Our Case Number: ABP-317742-23

Re: BusConnects Bray to City Centre Core Bus Corridor Scheme
Bray to Dublin City Centre.

Re. Planning Application by the National Transport Authority for the construction of the Bray to City Centre Core Bus Corridor Scheme.

The Submission from Dun Laoghaire Rathdown County Council regarding the Bray to City Centre Core Bus Corridor Scheme is set out hereunder.

Figure 23: Indicative Junction Phasing and Staging Diagram

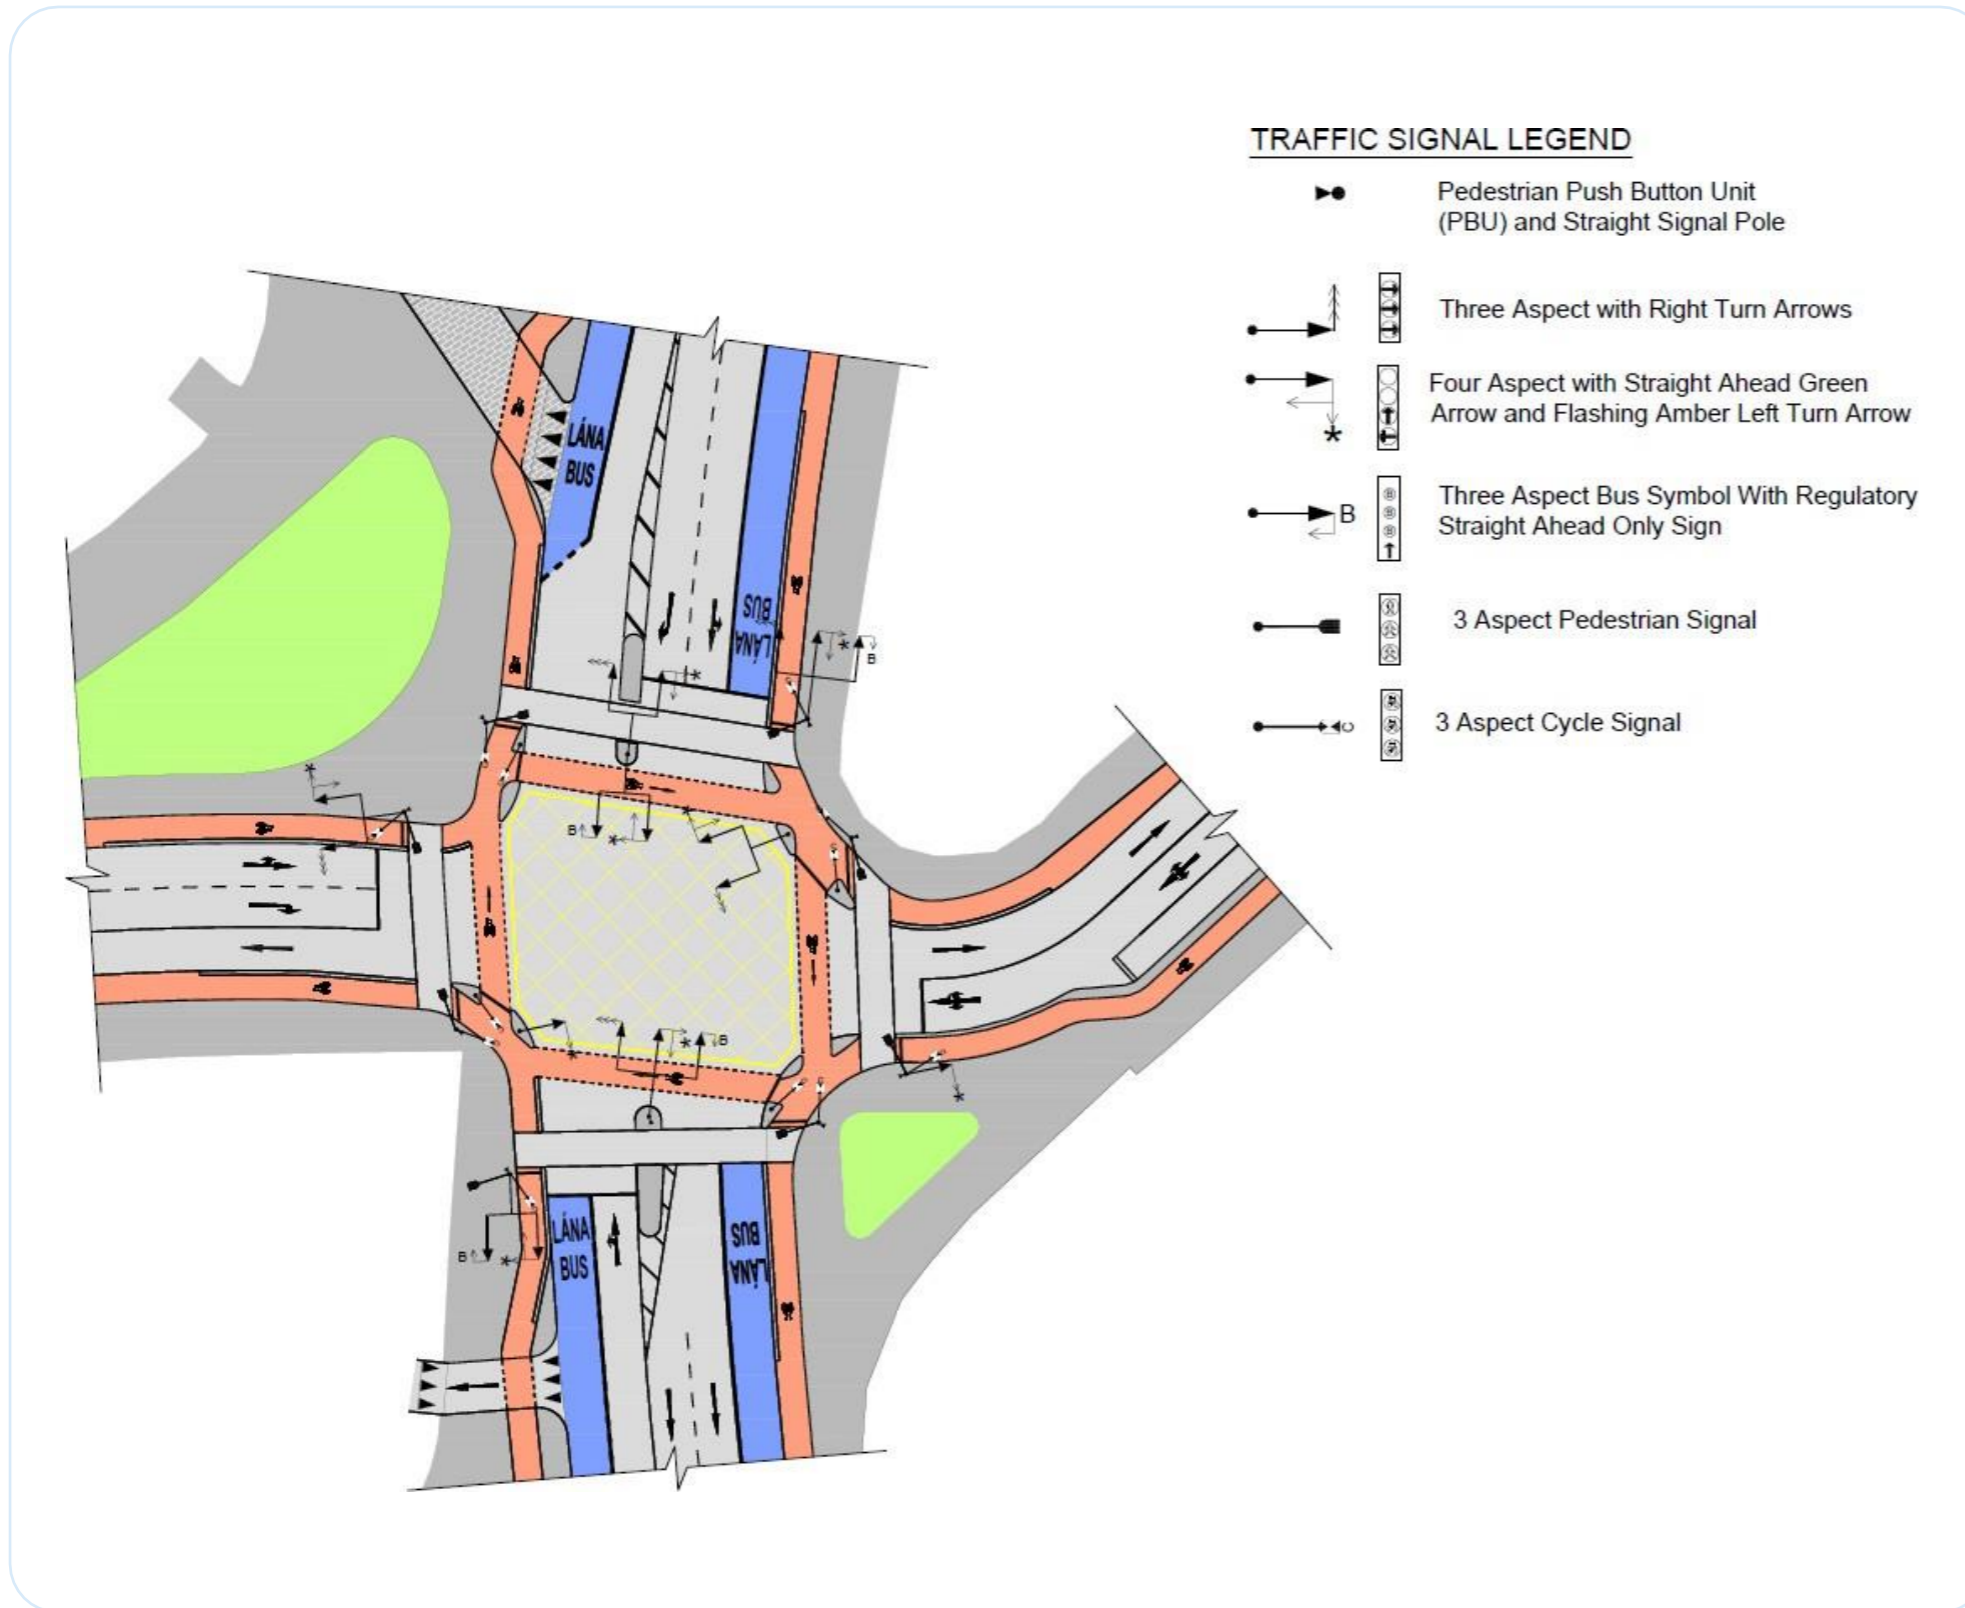
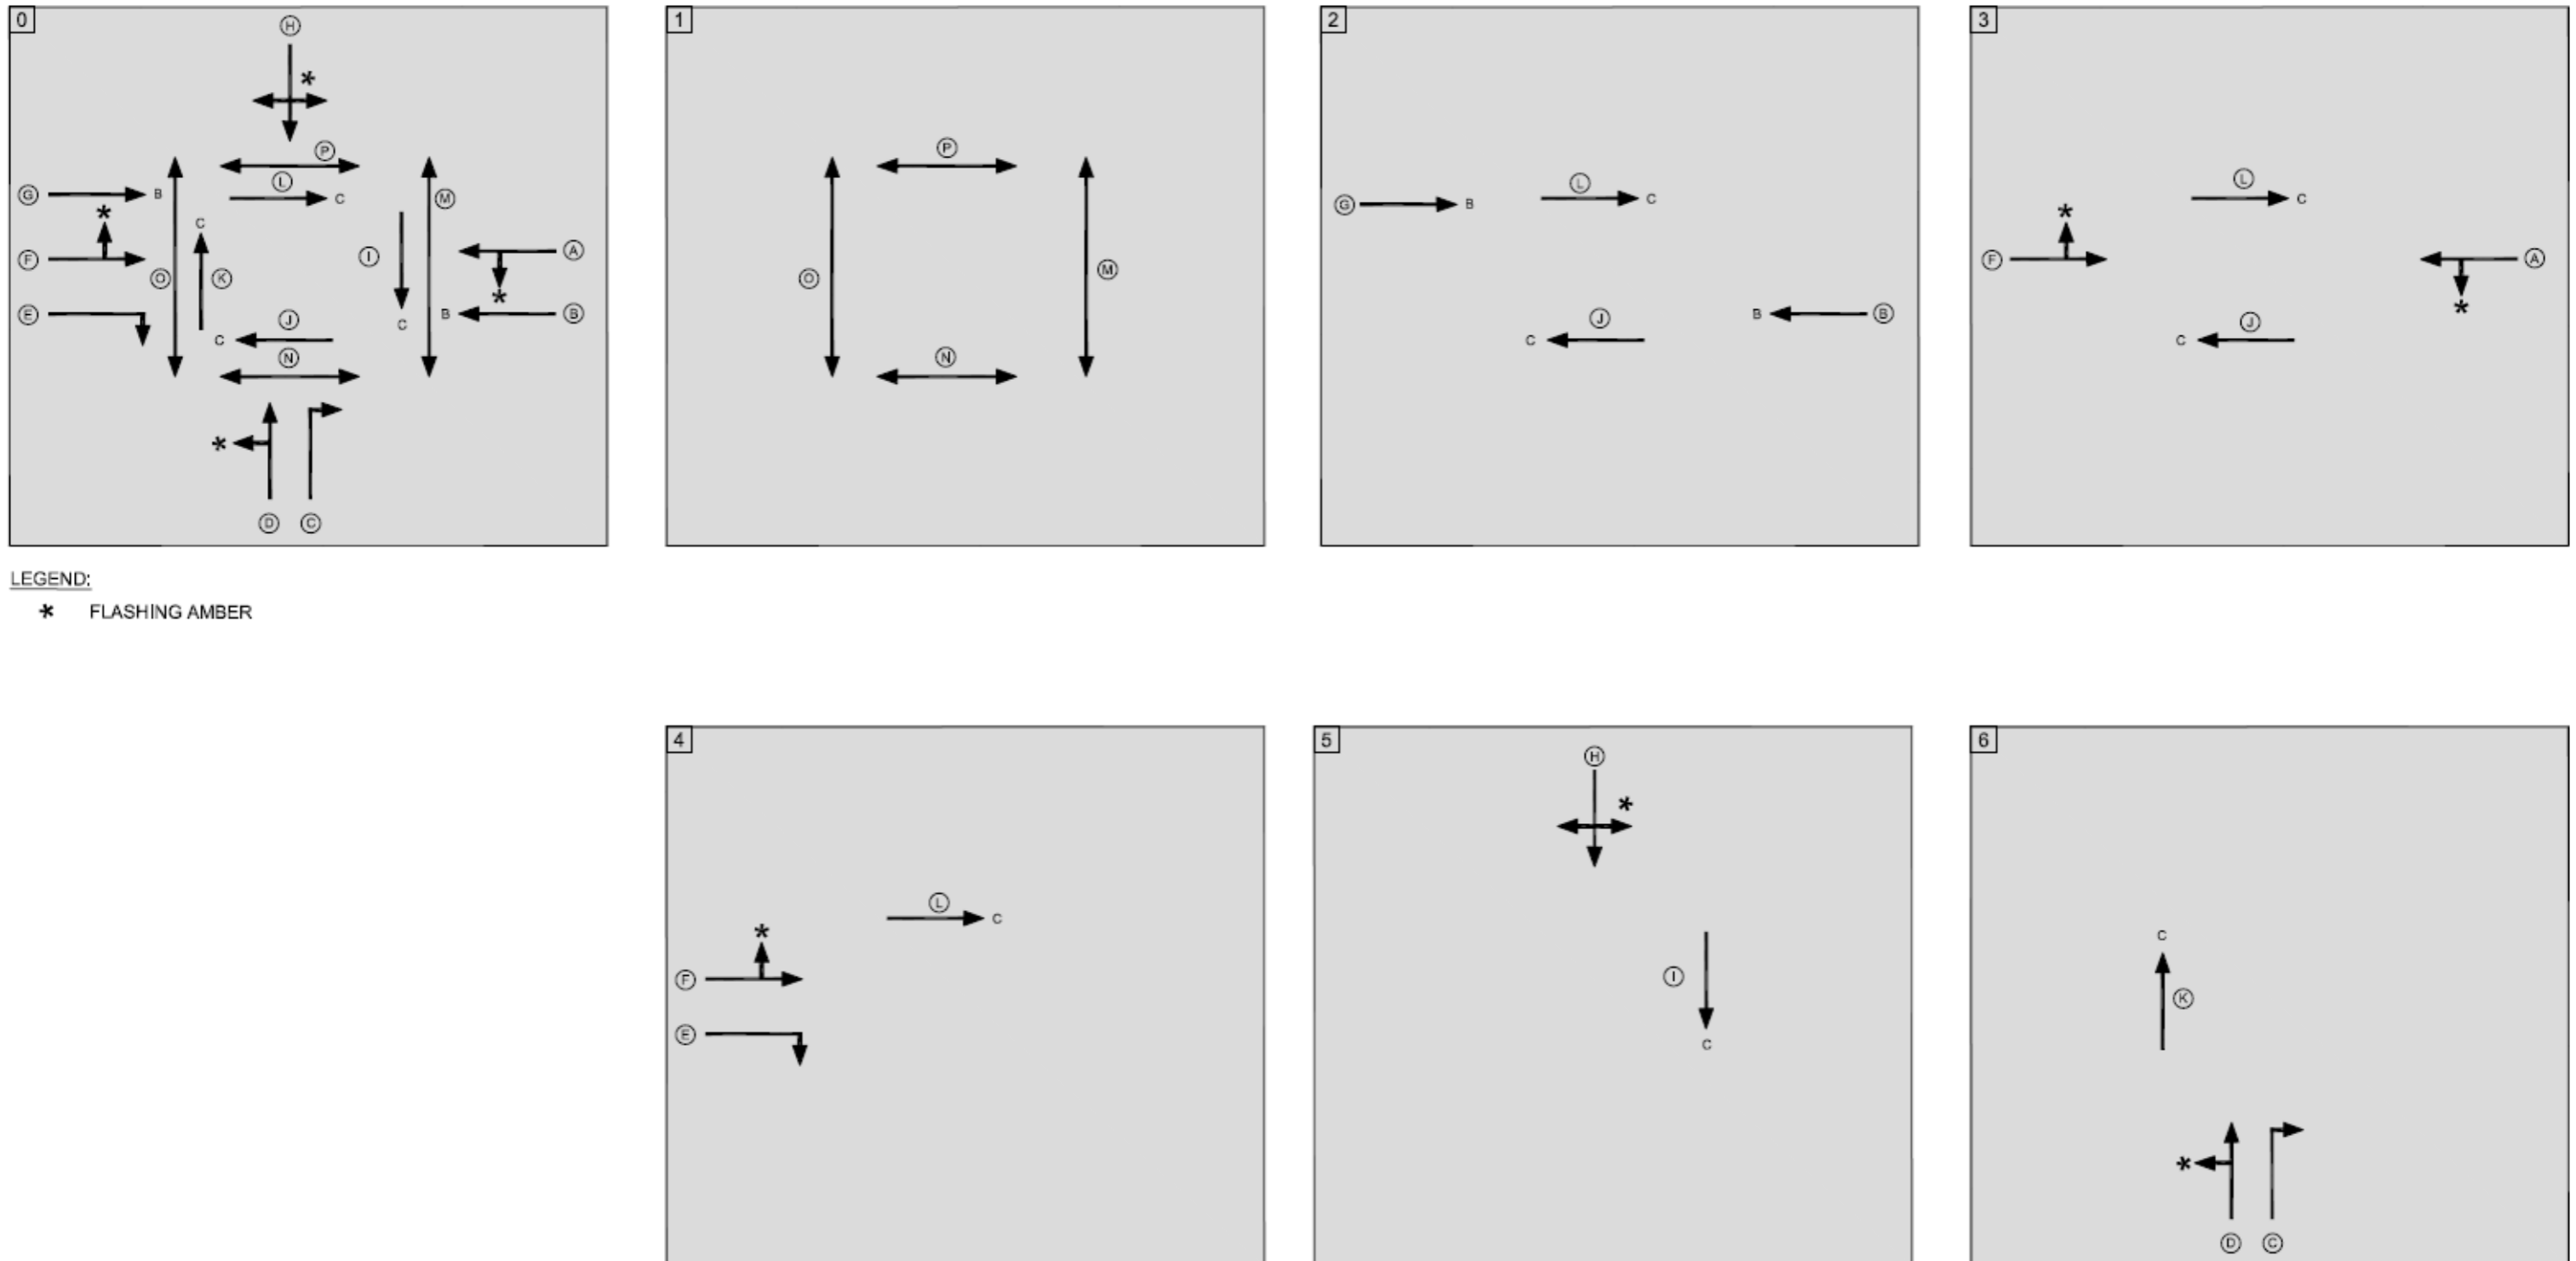
The Junction Design Report shows signal phasing and timings for the signalised junctions along the route. The Council has concerns regarding the design approach at a number of junctions.

The cycle times have been extended to 120 seconds “to maximise the throughput of people through the junction”. In fact, increasing the cycle time increases the throughput of cars only. Pedestrians, cyclists and buses do not benefit from longer cycle time. Pedestrians, cyclists and buses need minimum (or minimal) green time to clear the queues which have arisen during the red phase. It is only cars which require longer green times to clear the queues which have arisen during the red phase.

Where there is a conflict between straight through cyclists, buses and left-turning cars, a number of junctions have separate stages for each mode (presumably for perceived safety reasons). This means that straight through cyclists and buses have red signals while straight through and left-turning cars have green. Typically, in a cycle time of 120 seconds, the cyclist stage would be 7 seconds green, the bus stage would be 10 seconds green and the car stage would be between 20 and 50 seconds. Cyclists would have green for less than 6% of the cycle and buses for less than 9% of the cycle. This would be a very significant reduction in green time for cyclists and buses in comparison with the current situation, where cyclists and buses have green at the same time as cars.

The Council has a particular concern with the phase where straight through cyclists are on red while straight through cars are on green (typically for 20-50 seconds per cycle). The Council is concerned that the level of compliance by cyclists with such a phasing would be very low and that non-compliance would lead to significant safety issues.

The Council understands that a trial of similar junction layouts and signal phasing has been carried out in the Dublin City Council area, but at a junction with low cyclist traffic volumes, and other trials are being considered. The results of any such trials should be used to decide on the final detailed design of the junction layouts and the signal phasing for the Bray to City Centre CBC.

DLRCC requests that the Board include a condition requiring the NTA to implement and monitor a trial junction layout and phasing at a location (or locations) where there are significant volumes of cyclist and car traffic. The new Cycle Design Manual provides more up to date guidance on junction design. A permission for the Bray to City Centre CBC should allow sufficient flexibility for the results of any such trials and/or updates to the Cycle Design Manual, to be used to decide on the final detailed design of the junction layouts and the signal phasing and should require the NTA to agree the final detailed design of the junction layouts and the traffic signal phasing with DLRCC.
